Sent: 08 October 2013 23:05
To: Planning
Cc: Michel Saminaden
Subject: OBJECTION TO PROPOSED COUNCIL OFFICE EXTENSION

OBJECTION TO THE PROPOSED COUNCIL OFFICE EXTENSION
Ref: N6/2013/1938/MA

I am writing to object to the proposed extension to the WHDC Campus East Offices.

Title Proposed Materials

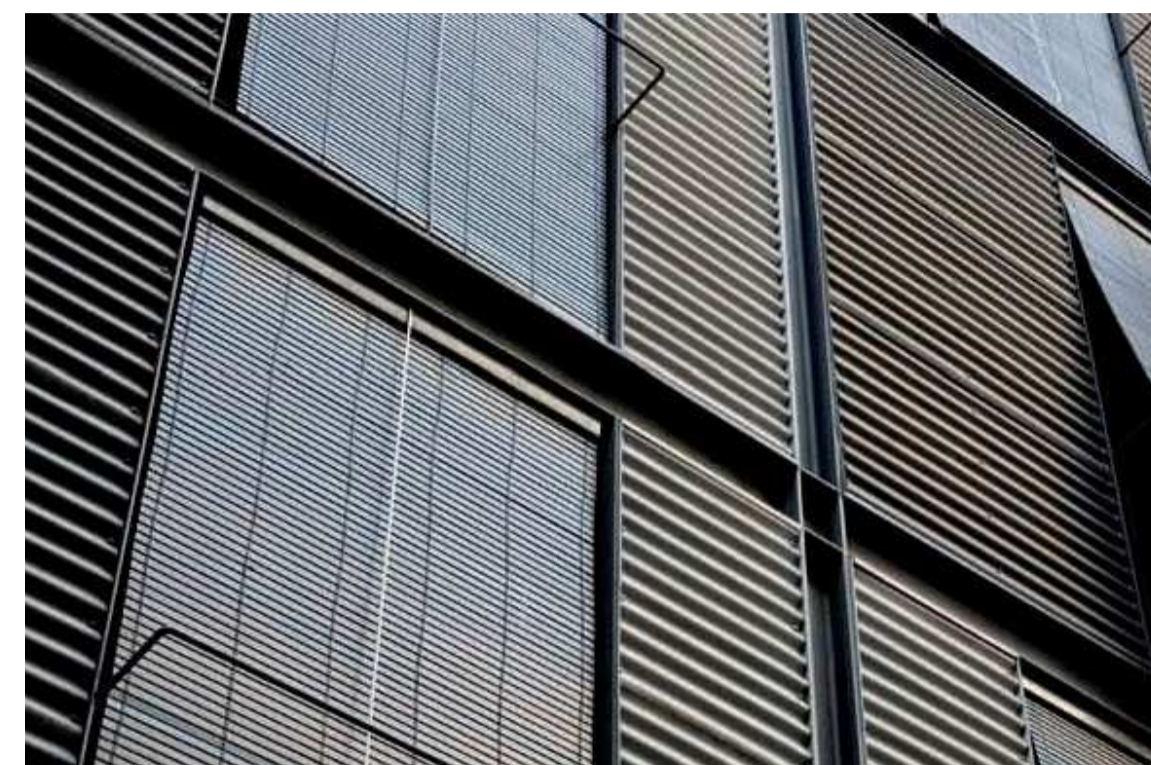
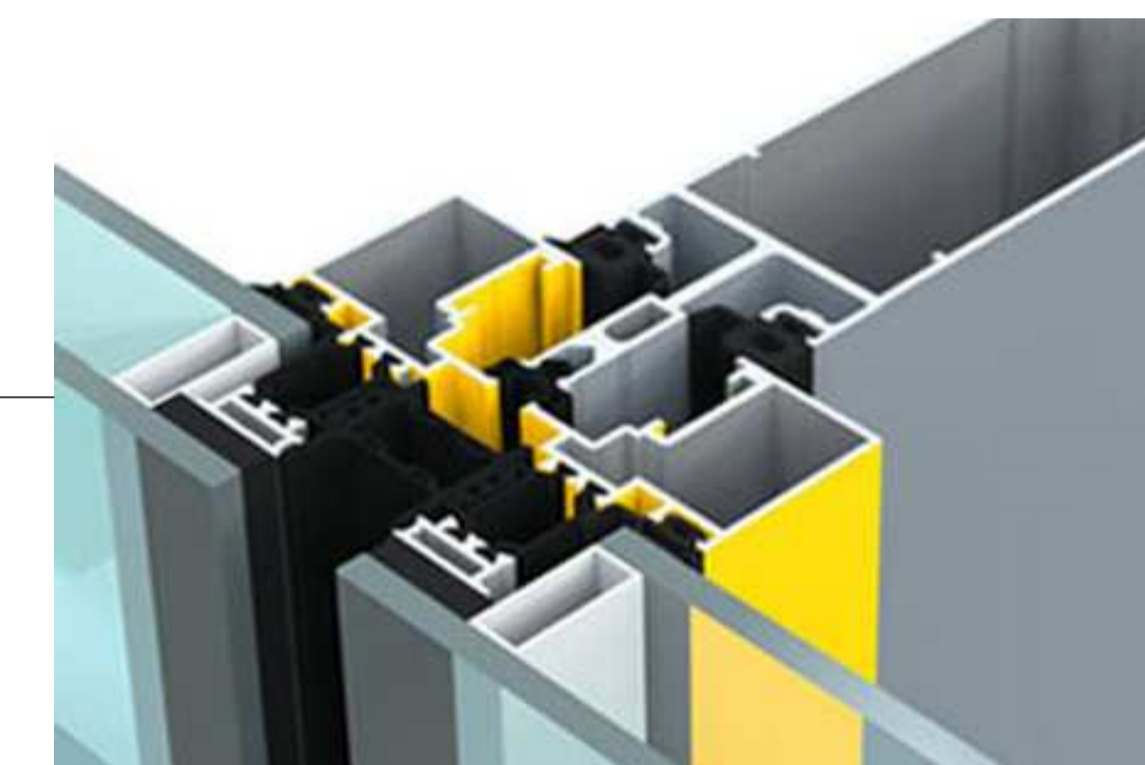
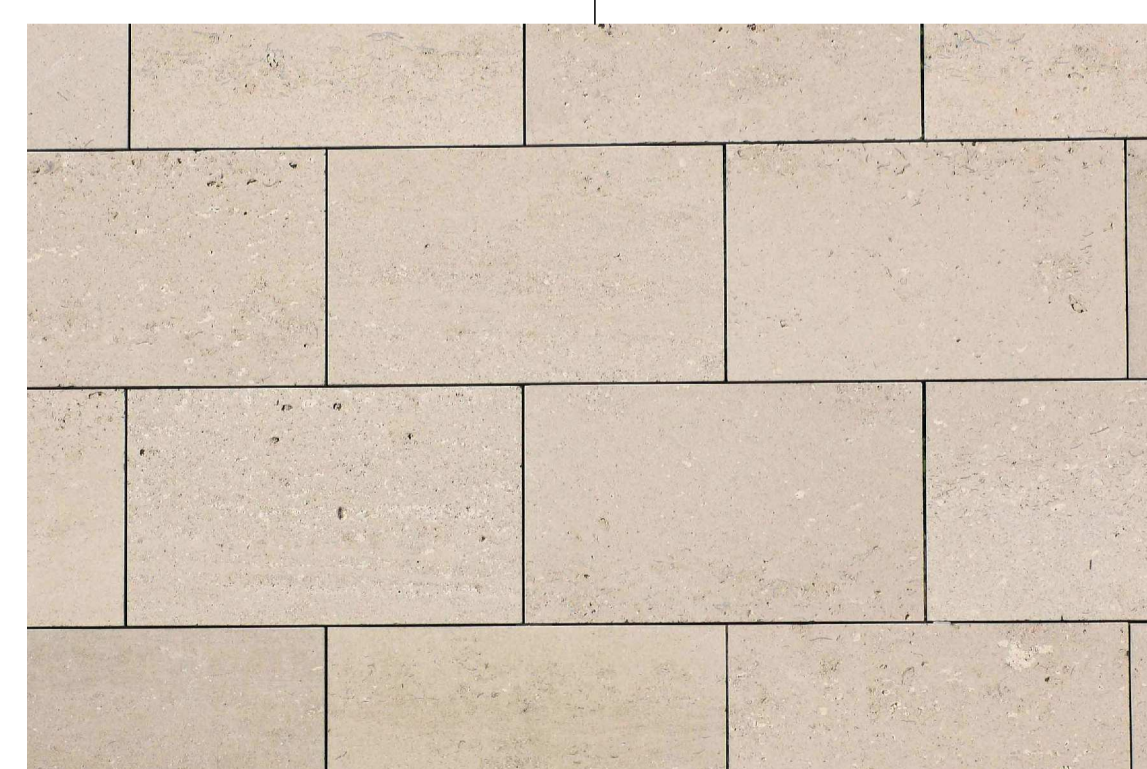
The proposed exterior is not in keeping with the existing building and is inappropriate given that the offices are in the conservation area. The design does not reflect the context, materials, proportions, nor the original features of the existing building, which was award winning when built.
